# Planning Services Sign Permit Review Form

Date of Submittal	Application Number	Applicant	Landowner
8/26/2021	SIGN2108-0001	Grey Outdoor LLC	STKI Leasing LLC

Contact Person	Contact Number	PIN Number	Sign Location
Guy Williamson	252-521-5555	1515-54-4695.000	1280 Bud Hawkins Rd.

ELEVATION VIEW

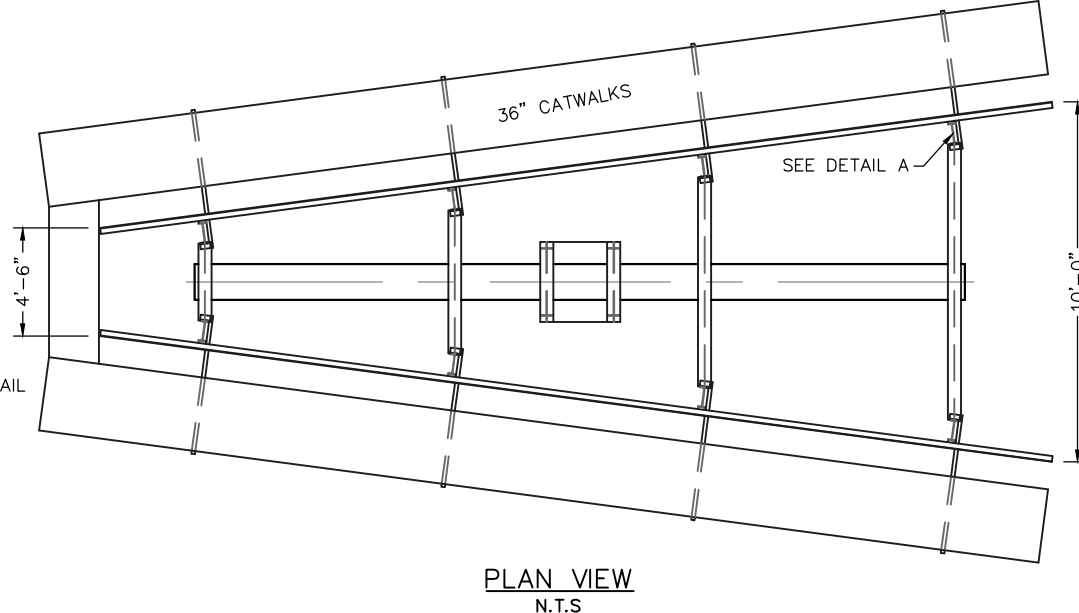
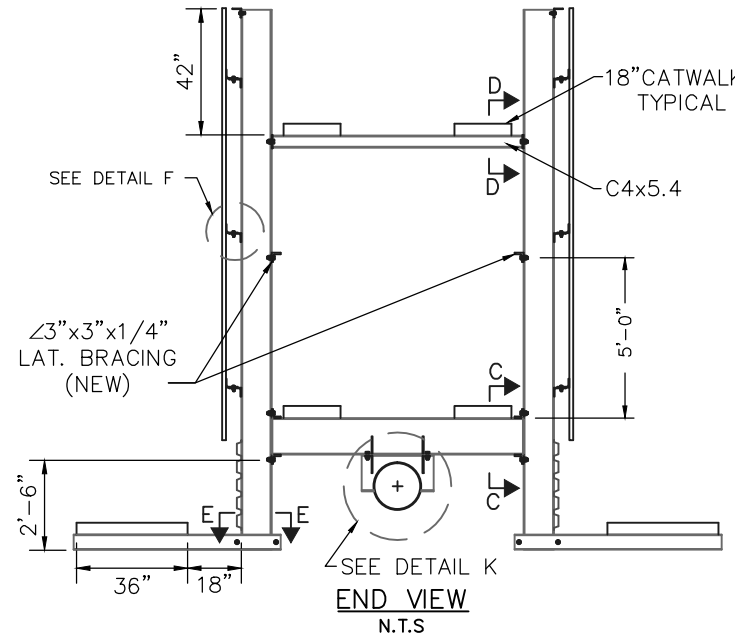
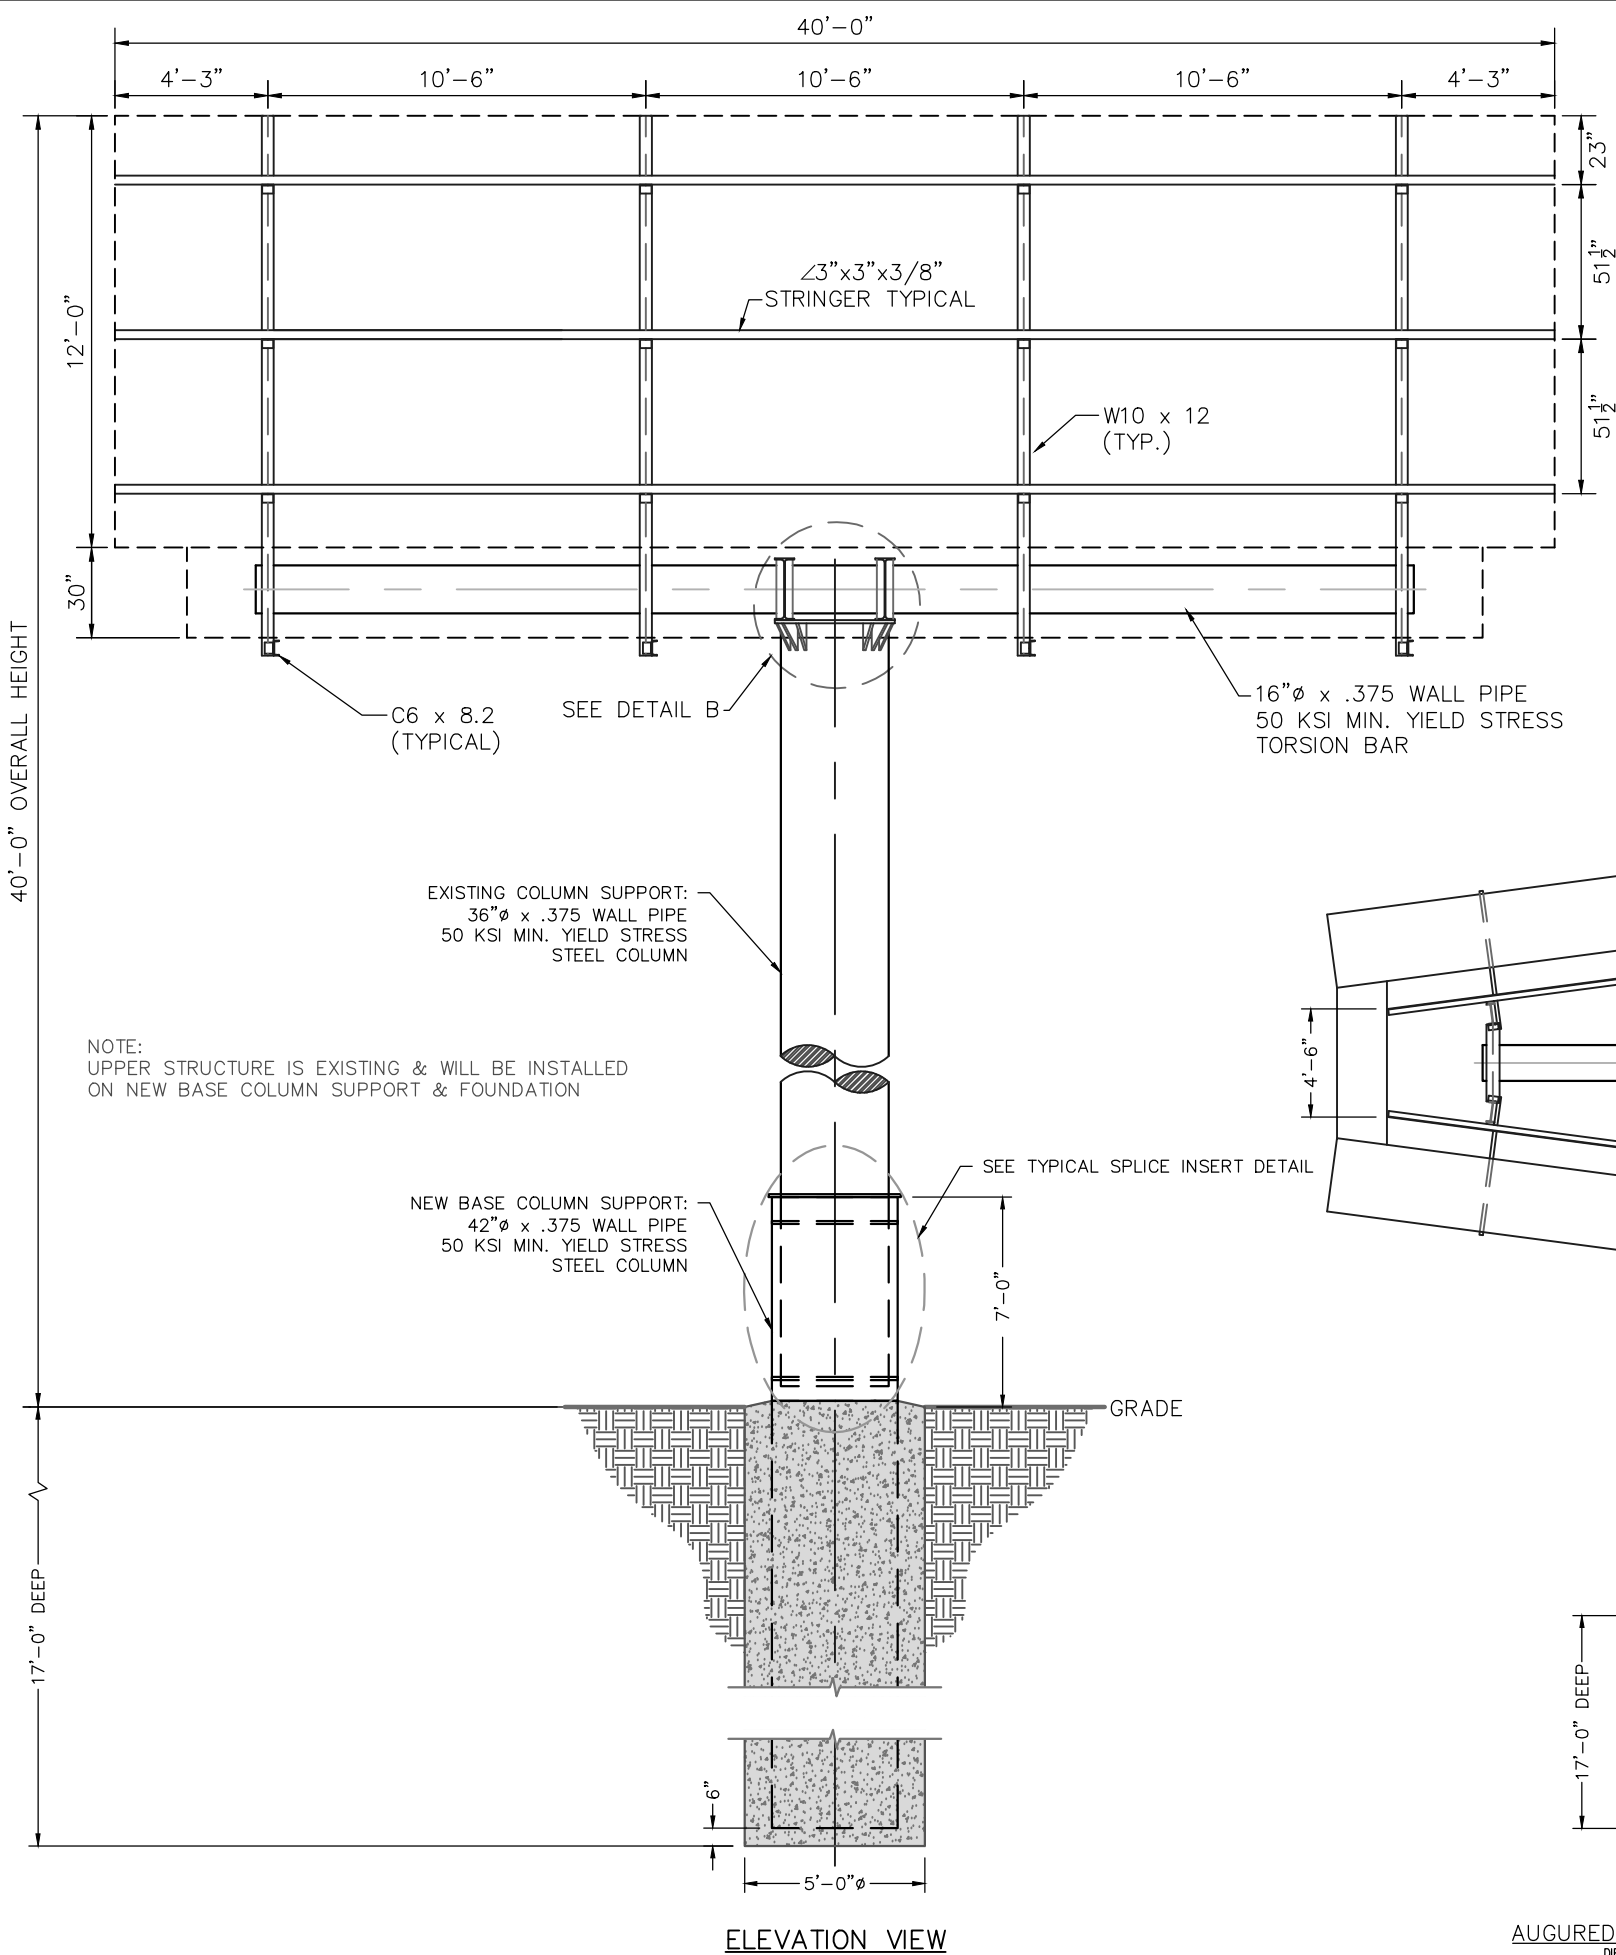
Comments	<p>General Sign Information: The sign is classified as a Business Sign: Interstate Highway. The sign is not licensed with NCDOT as a billboard. The sign <b>cannot be used</b> for the purposes of off-site advertising – now or in the future. The application submitted is for the sign to be relocated as apart of the I 95 widening project.</p> <p>Comments</p> <ol style="list-style-type: none"> <li>1. Please be advised that only 1 business sign is permitted on the property. No other ground sign advertising for the property will be permitted. If more than one sign is found to be located on the property, the sign will not be permitted to be relocated as proposed.</li> <li>2. The pool attached to the sign in the rendering will not be permitted when the sign is relocated. The structural plans indicate it is not attached. The pool will not be permitted to be attached to the sign.</li> </ol>
